THE MEMBER-SECRETARY,
Madras Metropolitan
Development Authority,
No.8, Gandhi-Irwin Road,
Madras-600 008.

Letter No. A1/4790/93

Sub: MMDA - Planning Permission - Construction of residential building in Plot No.111 at S.No.8/part, Velan Nagar of Valasaravakkam Village - Approval - Reg.

SITE PLAN

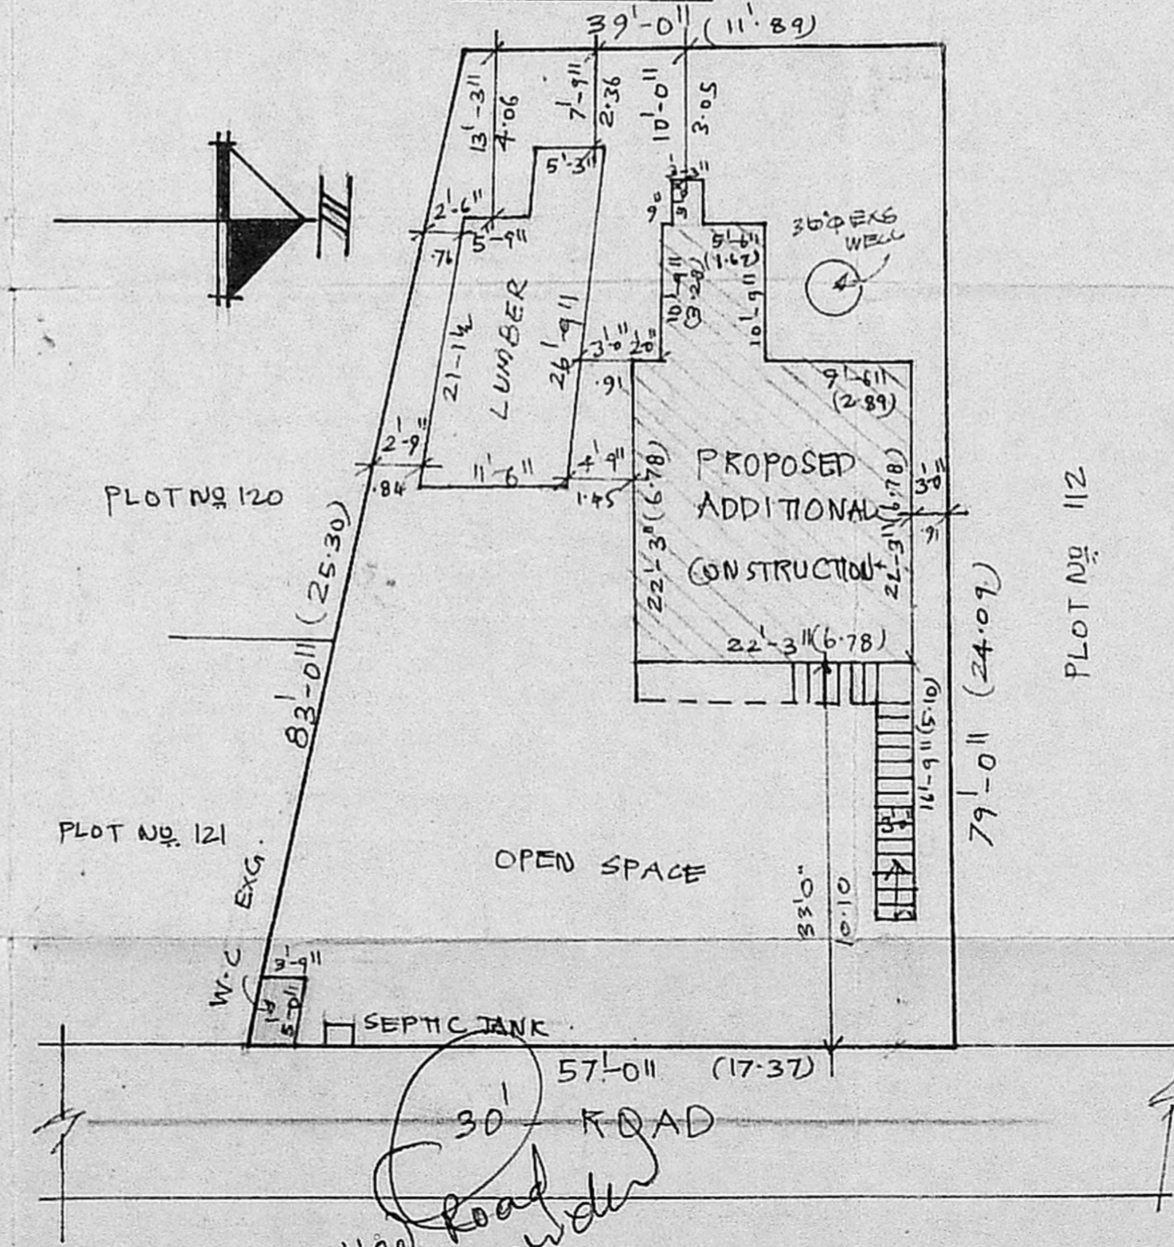
- 1) the existing WC in the Front Set Back should be demolished;
- i) 'in the open space within the site to the extent feasible trees be planted and the existing tree as preserved'
- iii) 'it was requested to ensure that the plans for the new buildings will incorporate the approved designs for mosquito-proof overhead tanks and wells'
- iv) ~~iii)~~ 'improvement charges and open space reservation charges and other charges as applicable'.
